From: Brenda Larsen
Sent: Tuesday, May 21, 2013 3:57 PM
To: Jeff Watson
Subject: RE: BL-13-00007 Grossman

Re: Grossman (BL-13-00007)

After conducting a review of the above named project, I have the following comments:

BOUNDARY LINE ADJUSTMENT SURVEY
PREPARED FOR
ROD GROSSMAN
A PORTION OF THE SW 1/4 OF THE NW 1/4 AND THE NW 1/4 OF THE SW 1/4,
OF SECTION 25, TOWNSHIP 19 NORTH, RANGE 17 EAST, W.M.
KITITAS COUNTY WASHINGTON

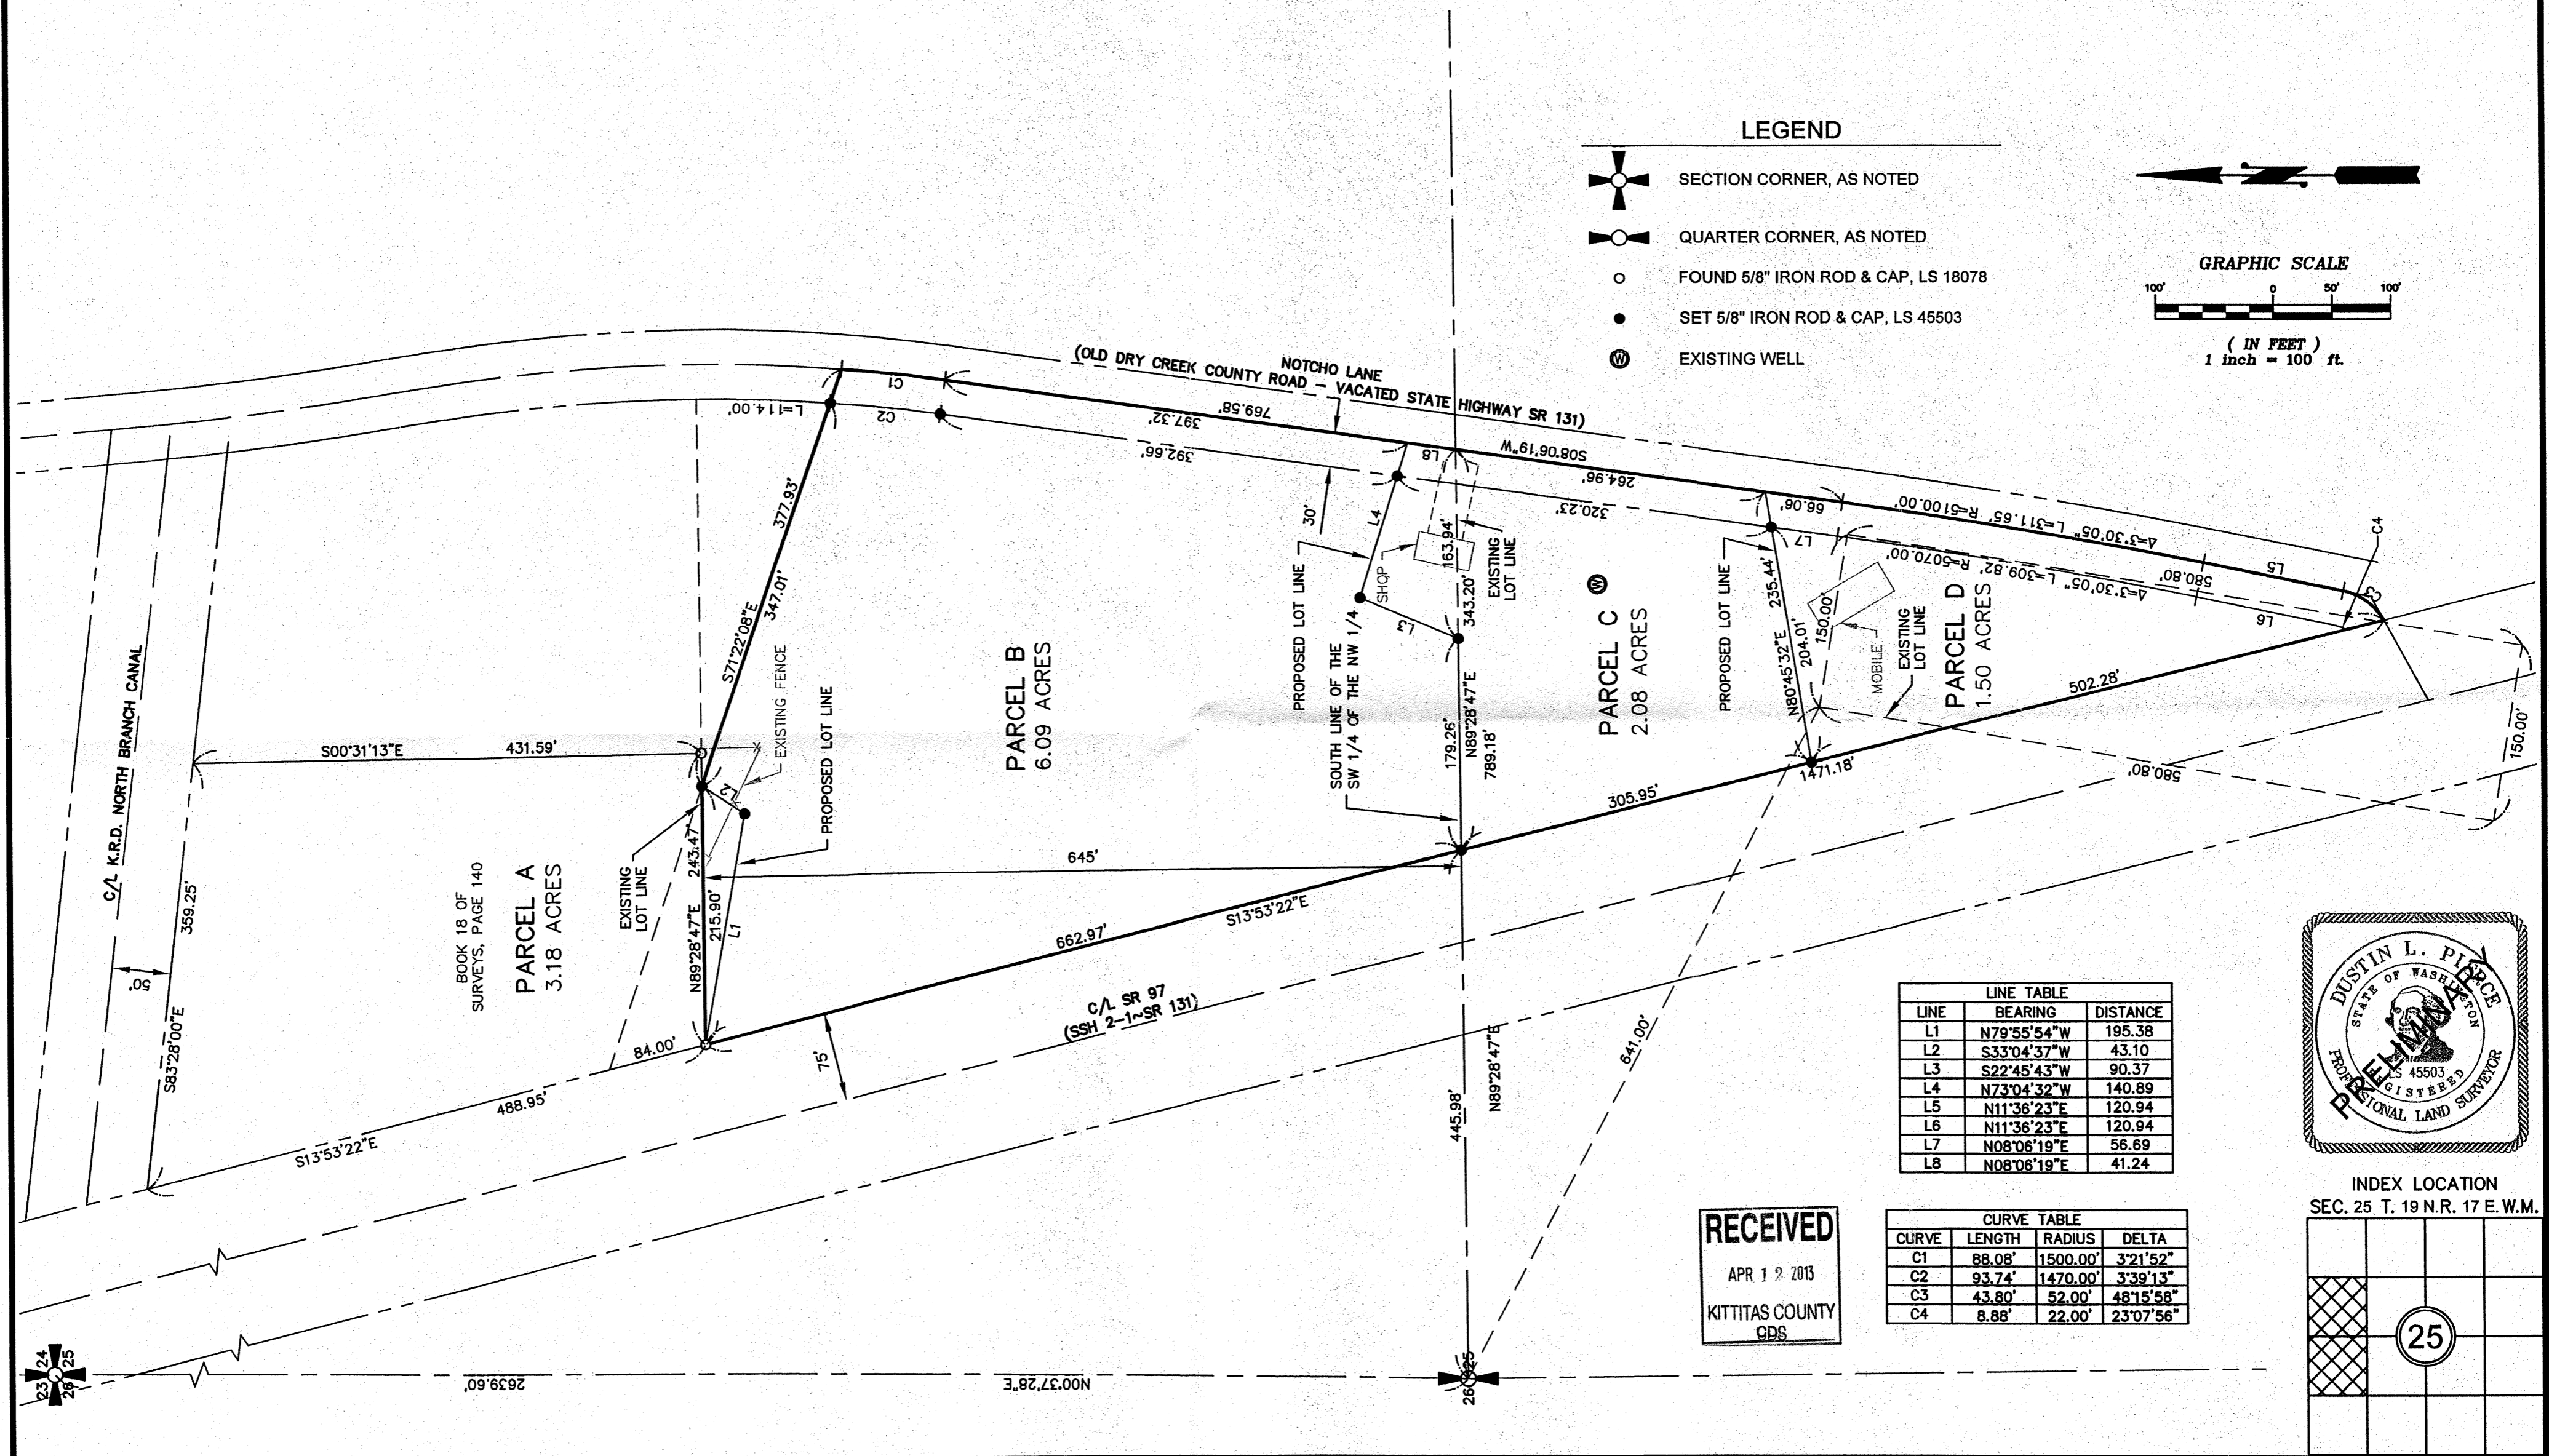
- Ensure that boundary line adjustments do not infringe upon existing structures, to include propane tanks, etc.
- Ensure adequate access for the fire apparatus.
- All future development must comply with the International Fire Code.
